# CITY OF ALBUQUERQUE

**Re: San Mateo Mixed-use Affordable Housing**  
**1000 San Mateo Blvd. SE**  
**Traffic Circulation Layout**  
Architect's Stamp 05-18-23 (L18-D087)

Plat for
Lot 1-A, Block 4
Esperanza Addition
Being Comprised of
Portions of Lots 1 thru 9, Block 4
Esperanza Addition and A Portion
of San Mateo Blvd SE Right of Way
City of Albuquerque
Bernalillo County, New Mexico
February 2023

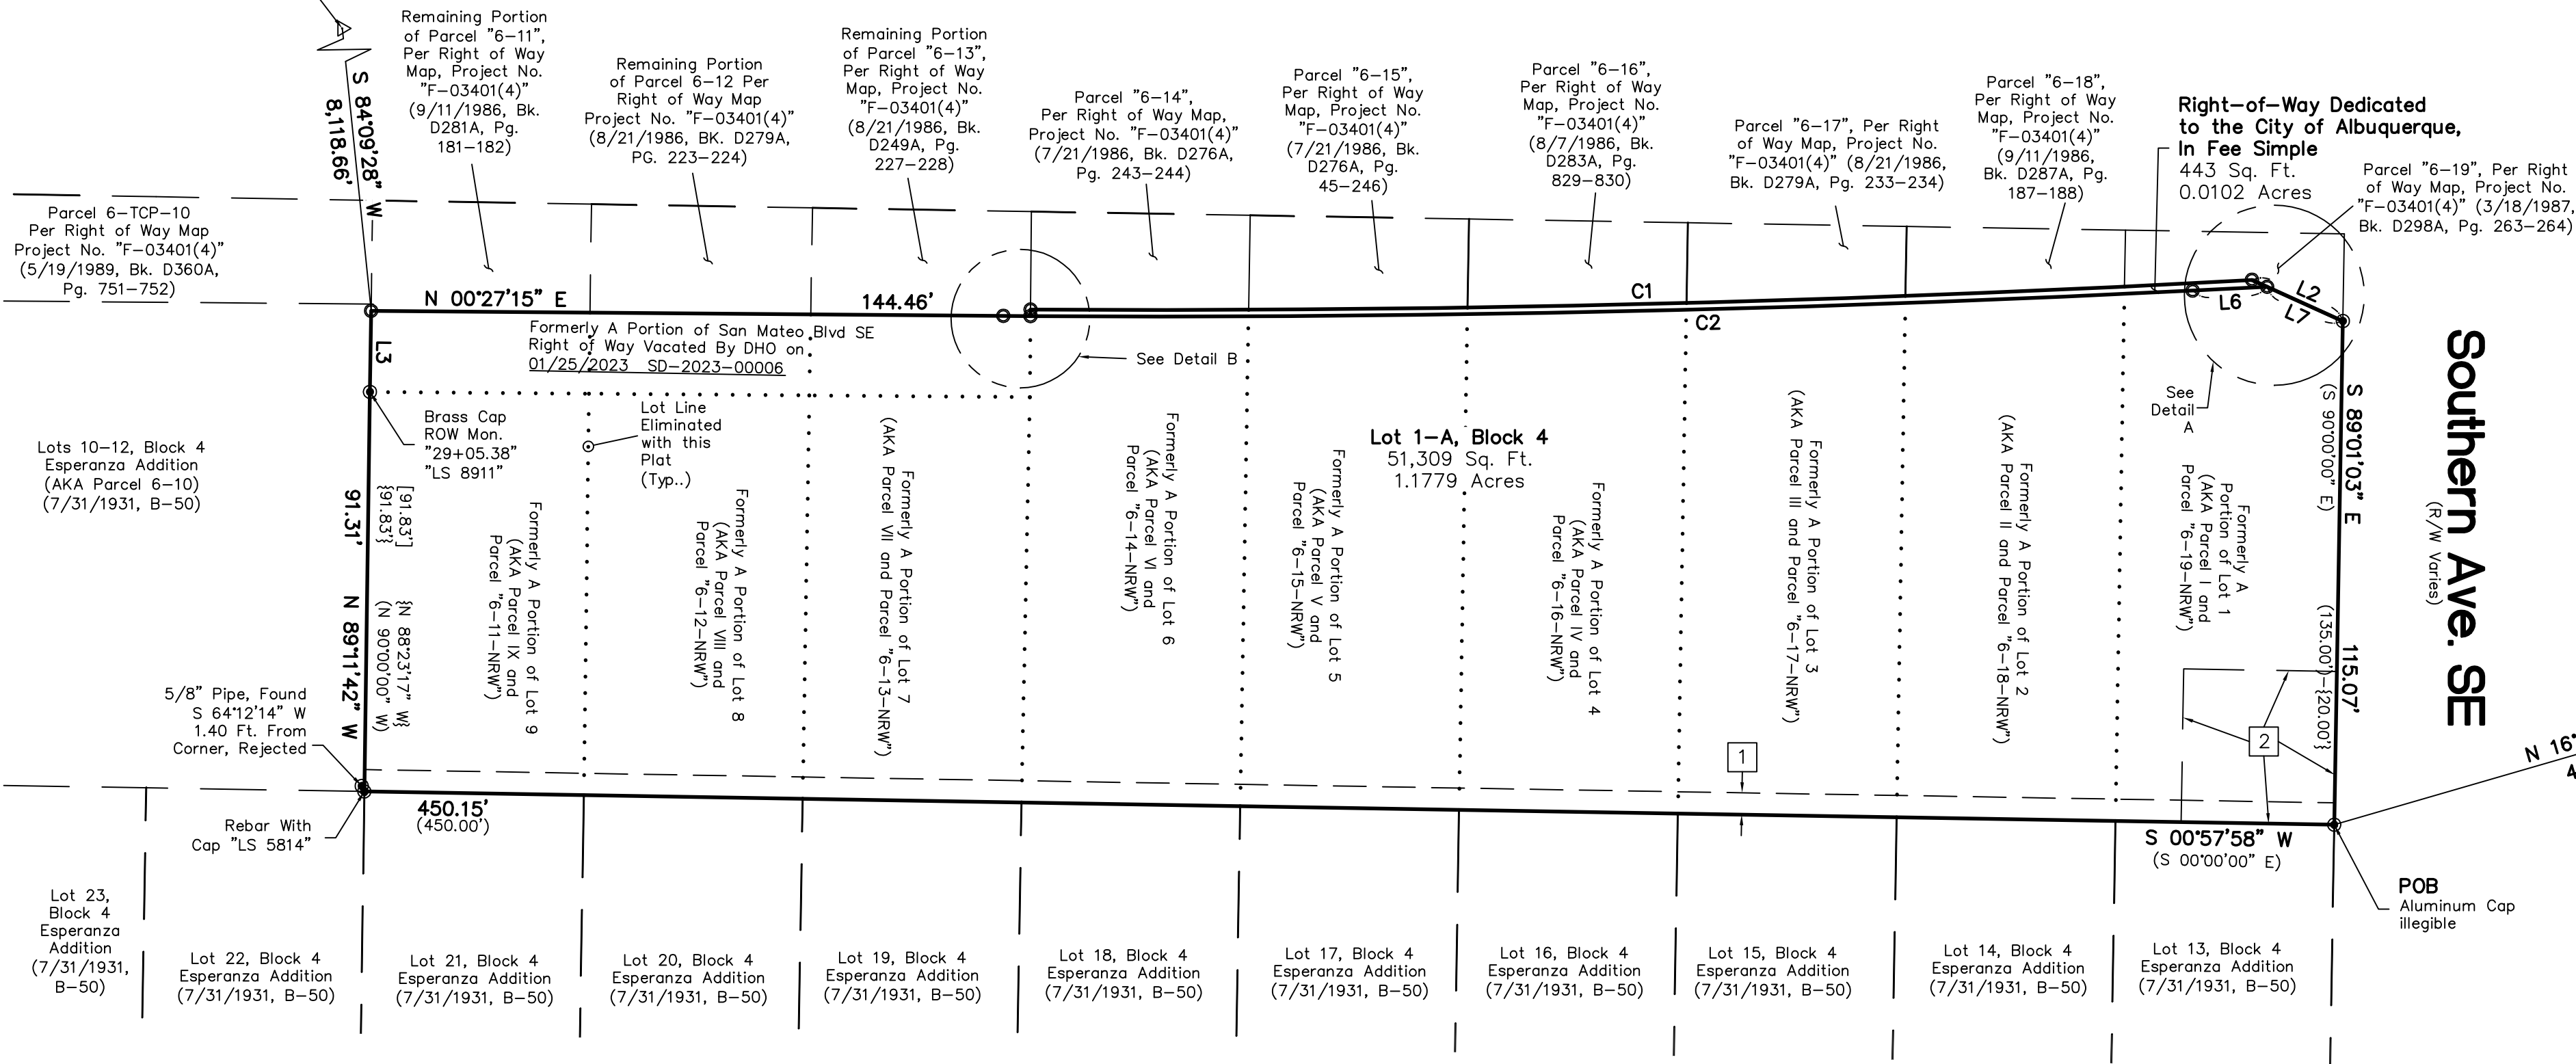
1. Identify all existing access easements, existing sidewalk width, and rights of way width dimensions.
2. Identify the right of way width, medians, curb cuts, and street widths on San Mateo Blvd. and Southern Ave.
3. The proposed site plan does not match the Google aerial. Please address this concern.
